From: Helberg, Carron [mailto:chelberg@usbr.gov]
Sent: Thursday, November 05, 2015 8:43 AM
To: CDS User
Subject: Big Creek Trails Rezone - Pat Deneen

Comments to Kittitas County on RZ-15-00001, SD-15-00002, SD-15-00003:

The Yakima Field Office of the Bureau of Reclamation (DOI), has the following comments on this project:

RZ-15-00001

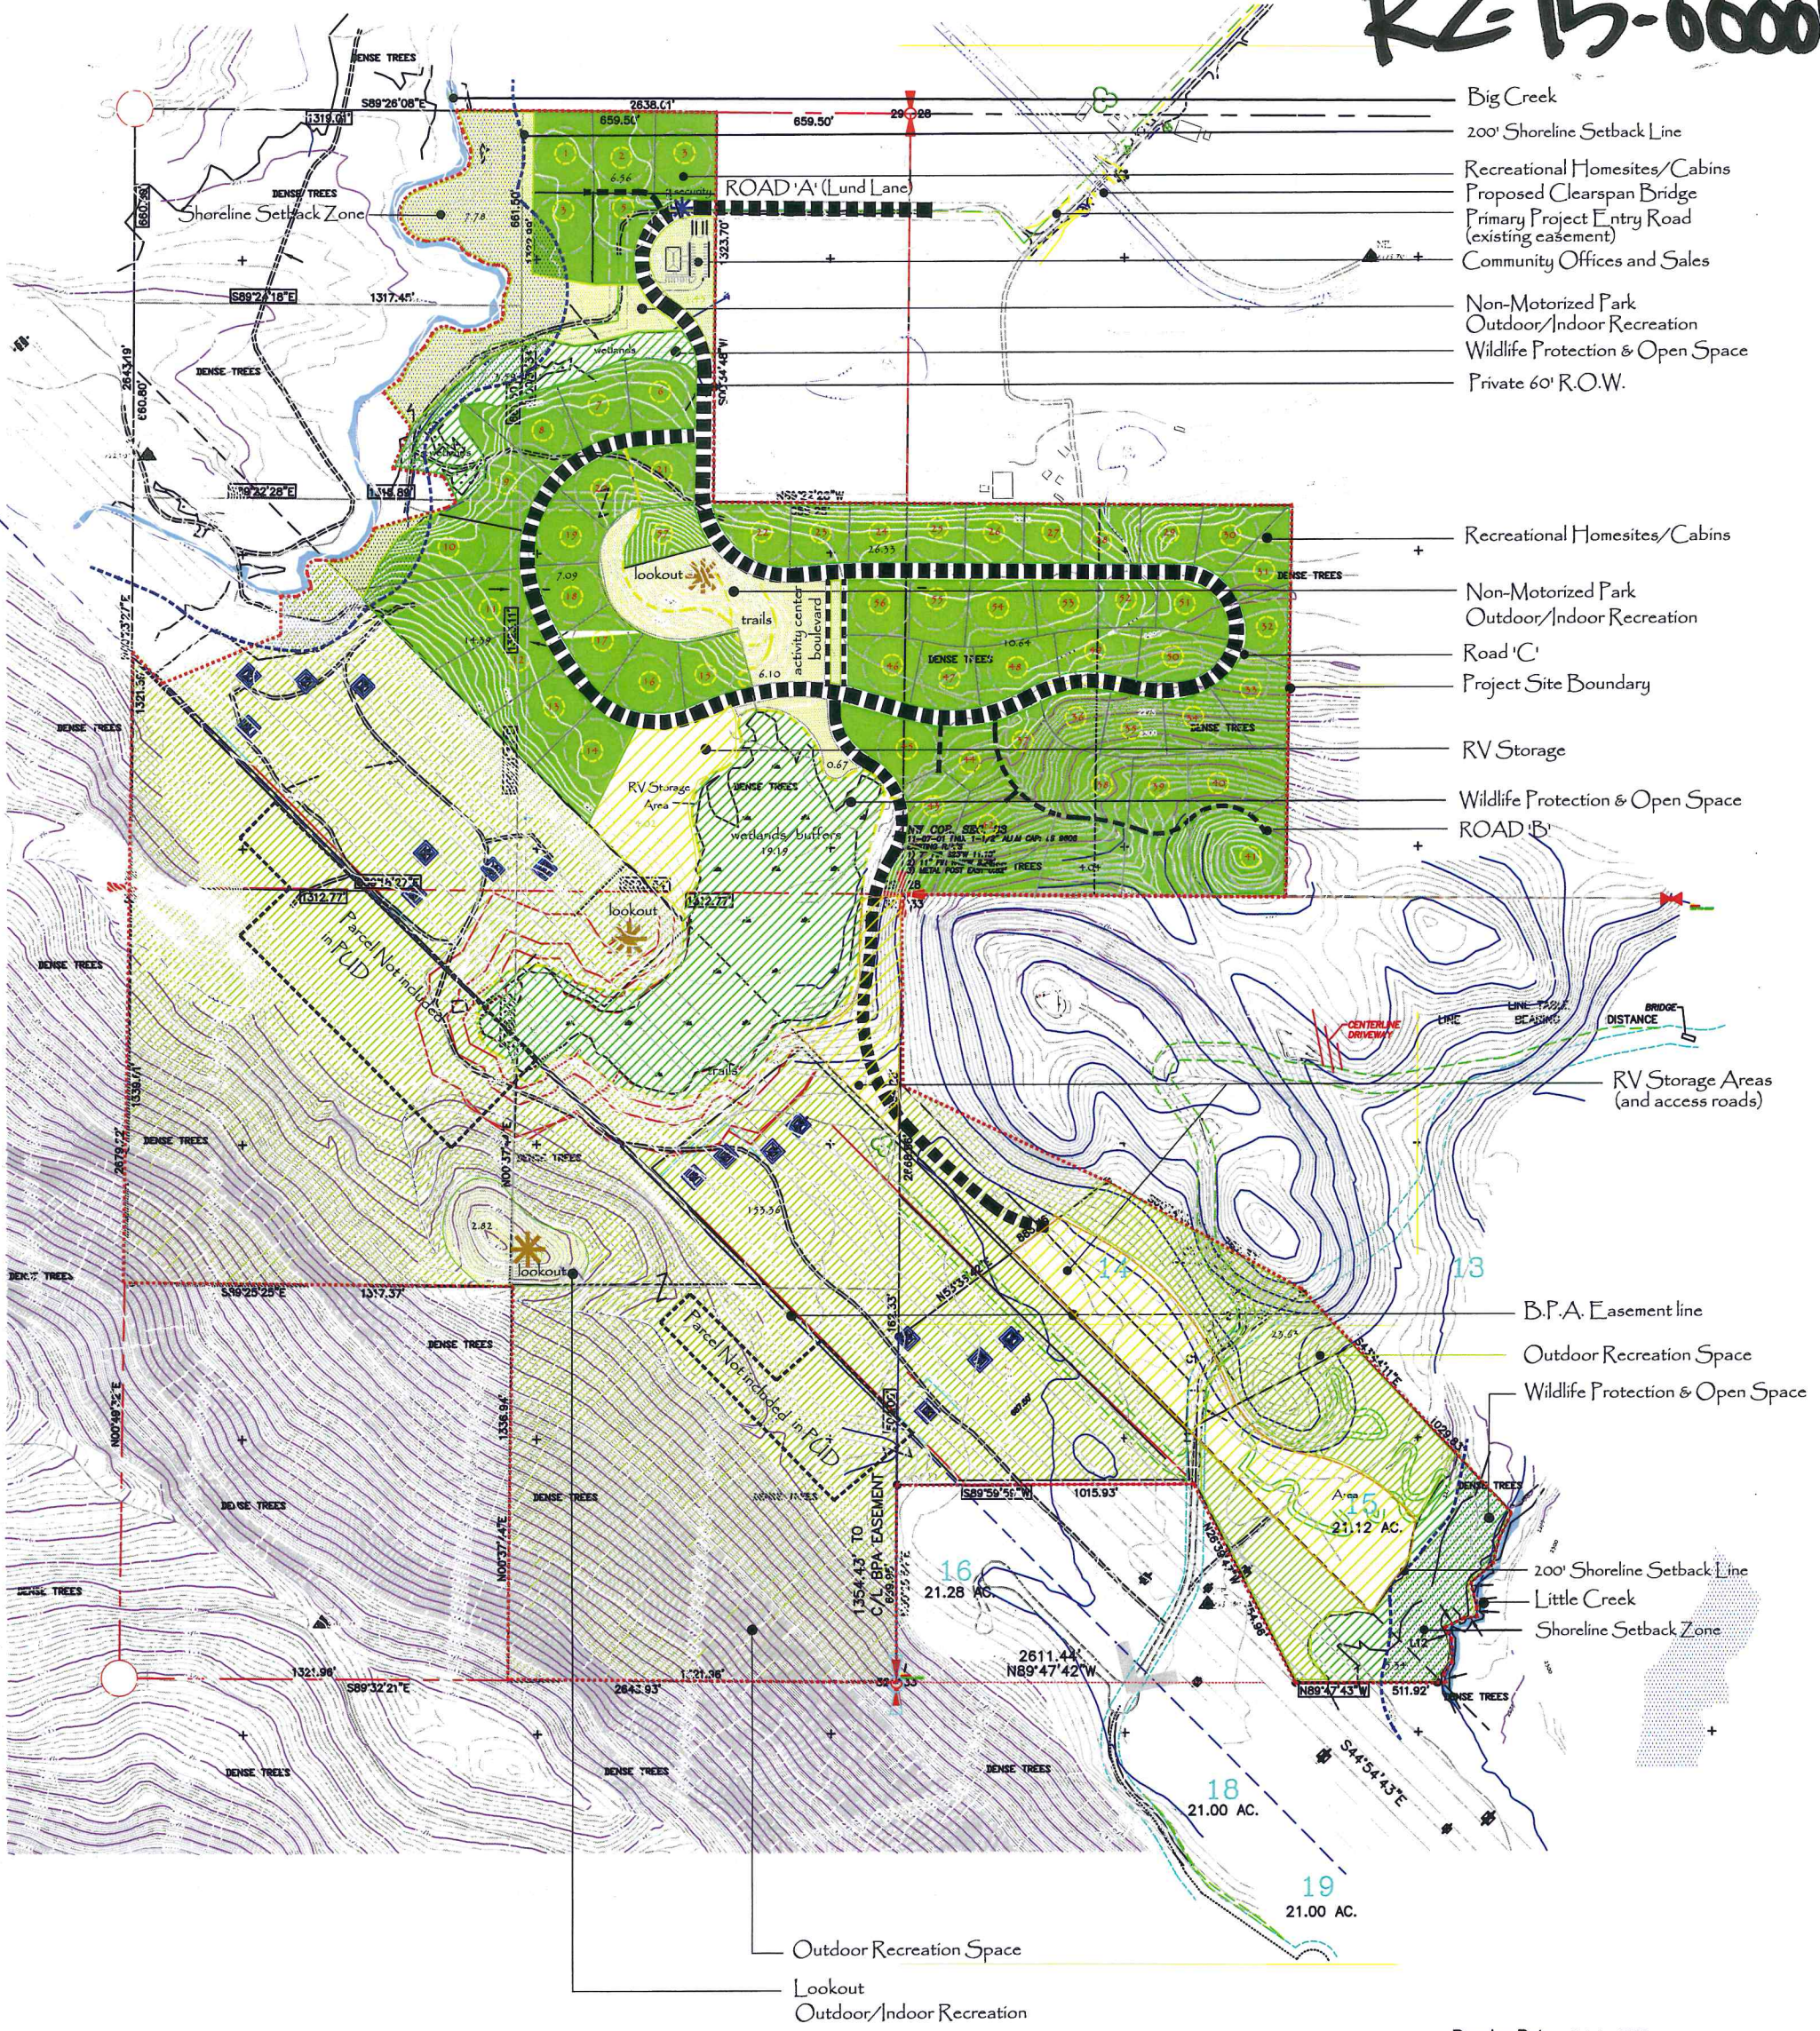
The bridge over the Kittitas Reclamation District Main Canal is owned by the United States. The proponent will be required to work with the Bureau of Reclamation as part of this project in order to replace it, which involves transferring ownership of the bridge out of the name of the United States.
